Planning Inspectorate

Date: 03 December 2025

ONE EARTH SOLAR FARM

RESPONSE TO DOCUMENTS SUBMITTED AT DEADLINE 5

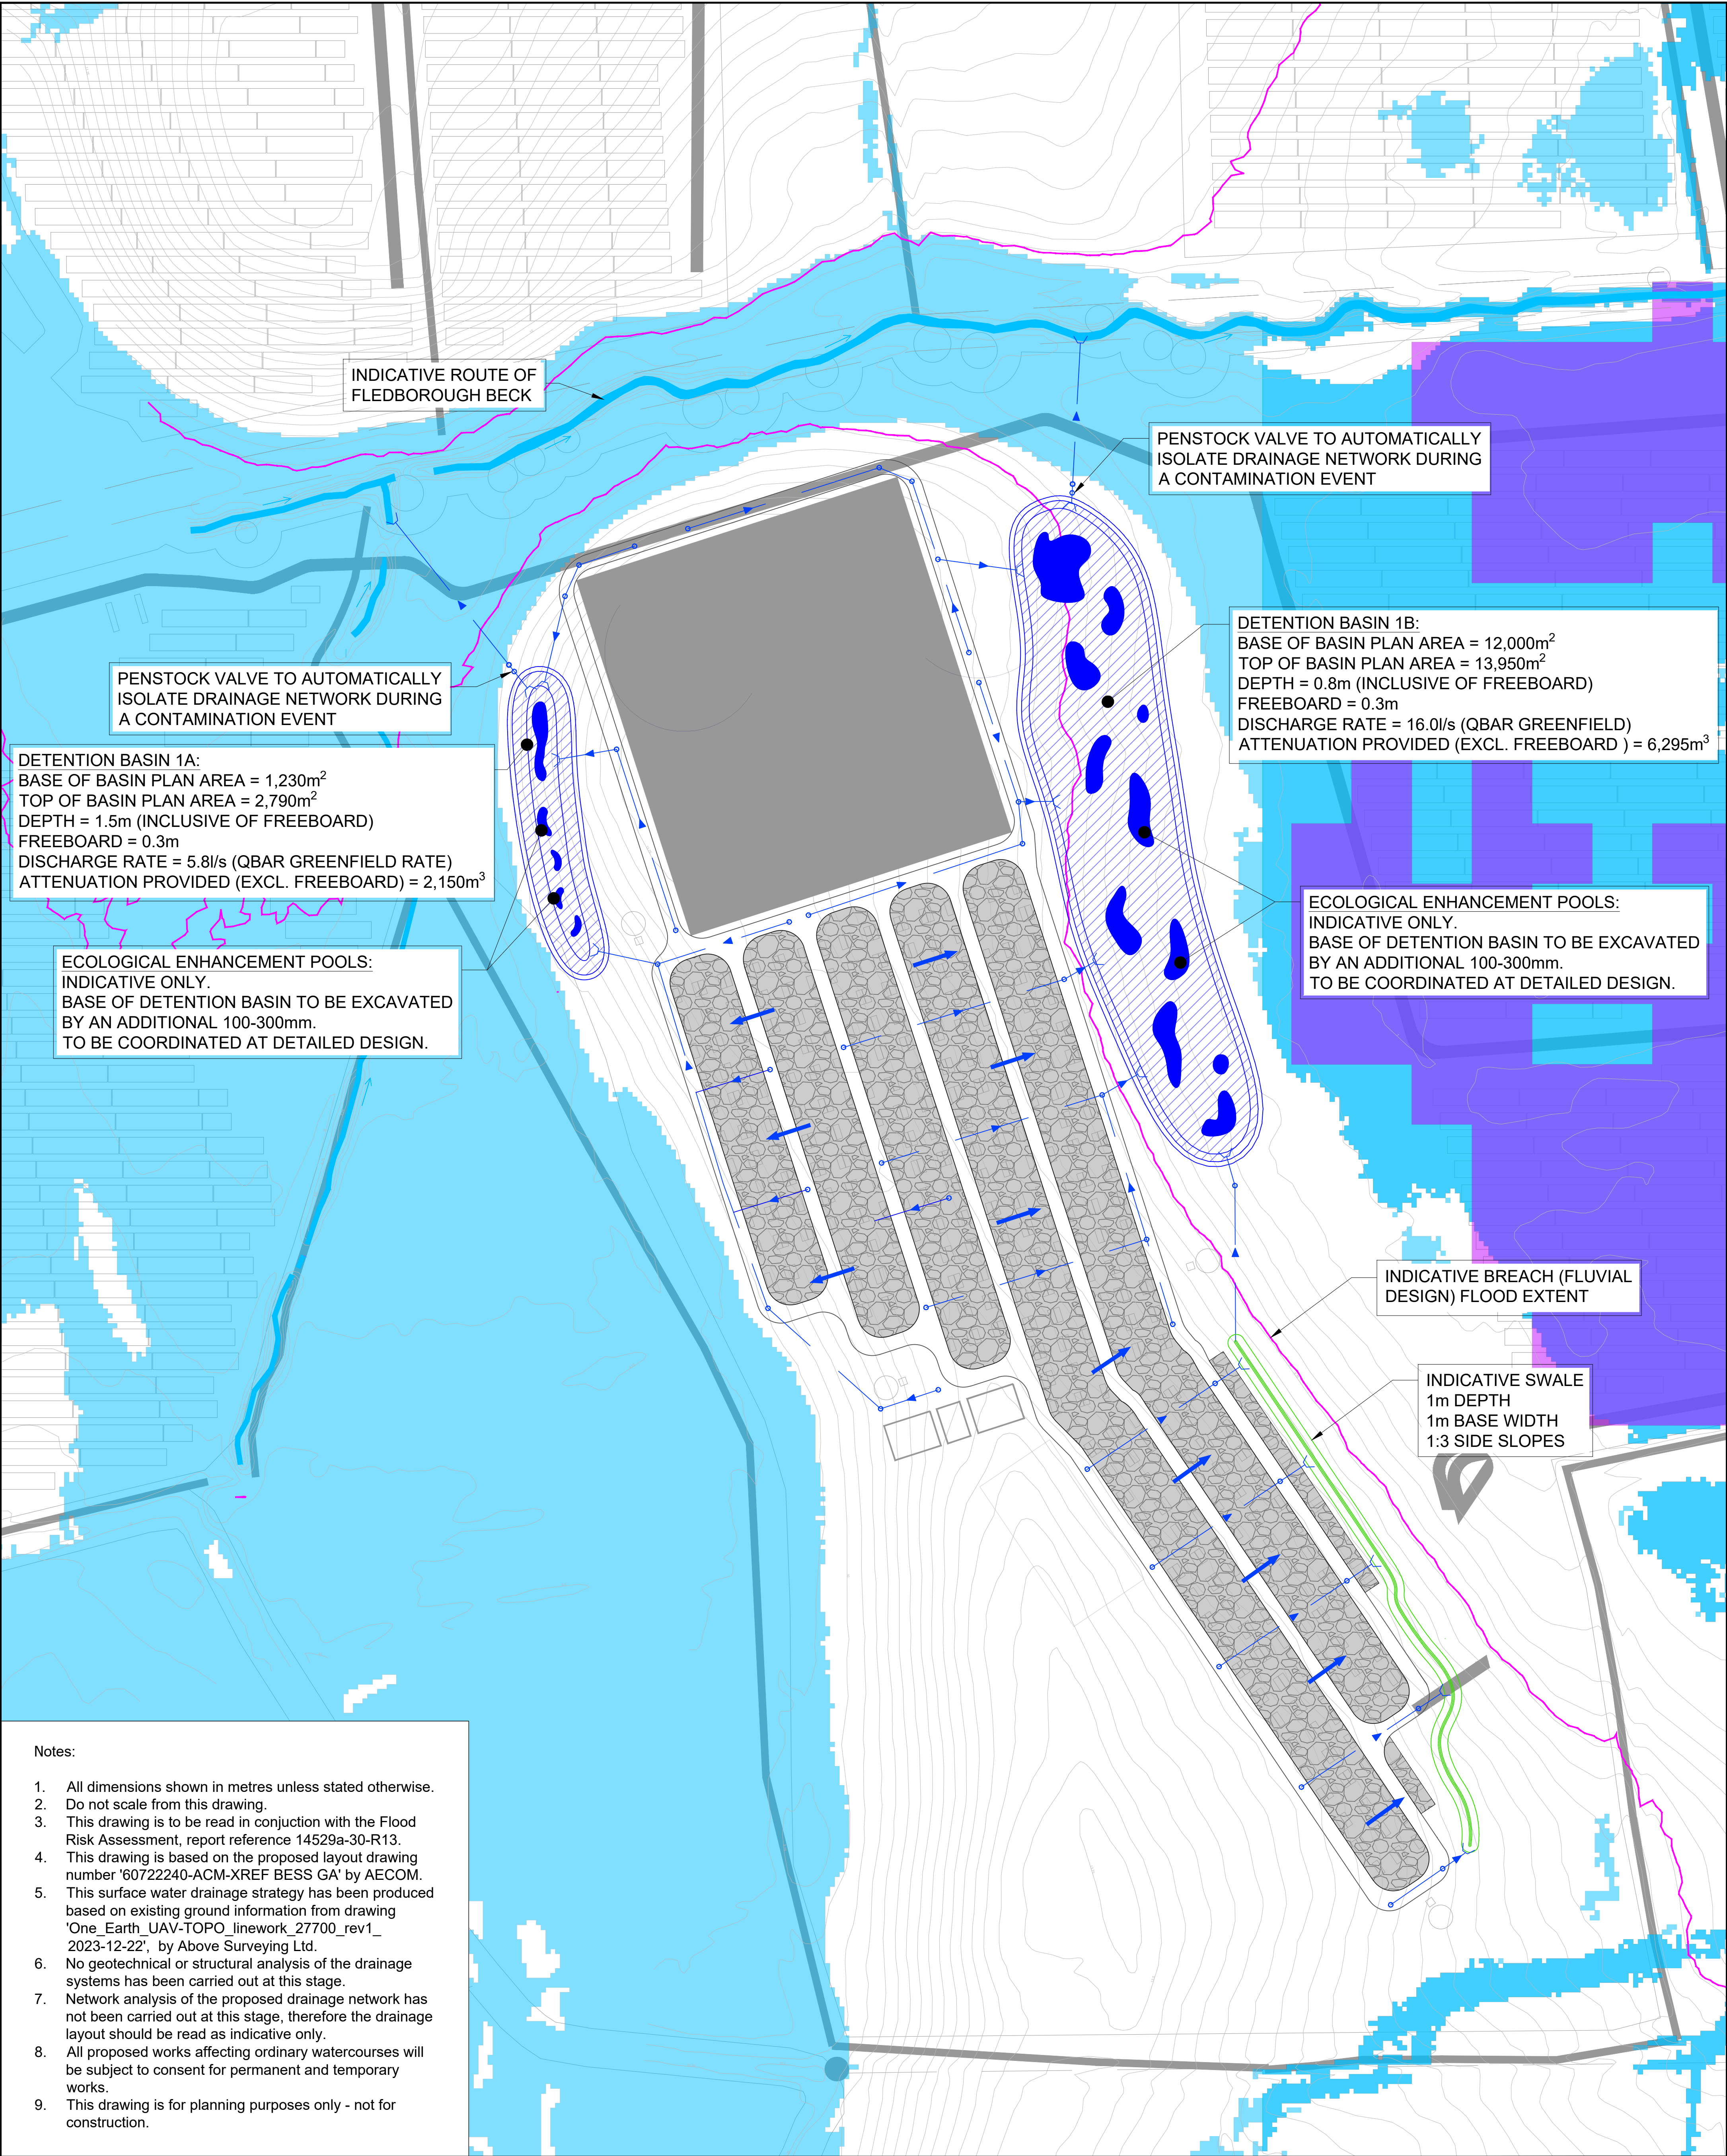
Outline Battery Safety Management Plan	Comments:	<p>Figure 2.2 of the oBSMP shows a notably different layout from that shown in the drawing ‘Surface Water Drainage Strategy Eastern BESS Compound’ presented in the FRA and Drainage Strategy. These should be consistent with one another.</p> <p>Section 3.5.31 refers to the use of an aerosol suppression system within the BESS enclosures, which may involve ‘Clean agent’ extinguishing systems. Section 4.5.3 later refers to the possibility of the use of a ‘dry agent’ system. It is unclear whether these are the same systems. The Applicant should confirm that no suppression systems will contain</p>
--	-----------	---

<p>from entering the drainage network. This information should be included for completeness.</p> <p>Table 4-1 states that “Features serving the BESS compound areas will therefore have an impermeable lining to prevent infiltration to the ground.” This sentence should also include the Substation compound areas for consistency.</p> <p>Table 4-10 presents a summary of indicative SuDS maintenance proposals. This should also include proposals for the inspection and maintenance of surface water drainage pollution prevention infrastructure such as bunds and oil water interceptors.</p> <p>The Maintenance Regime section on Page 63 contains a typo “<i>third part</i>”, which should be corrected.</p> <p>Drawing title ‘Surface Water Drainage Strategy Eastern BESS Compound’ shows two detention basins, Detention Basin 2 and Detention Basin 3. These are shown discharging via automatic penstock valve to two indicative ordinary watercourses. Our records contradict the layout of the ordinary watercourses as shown in the drawing – the northern ordinary watercourse, receiving water from Detention Basin 2, is consistent with our data, however the southern ordinary watercourse, receiving discharge from Detention Basin 3, is not present on our records. Our records show the indicated discharge point instead connects to an unnamed ordinary watercourse which flows northward to join the same ordinary watercourse that Detention Basin 2 is shown to discharge to. The Applicant should confirm the drainage layout at the proposed discharge points and update the figures accordingly if found to be inaccurate.</p>
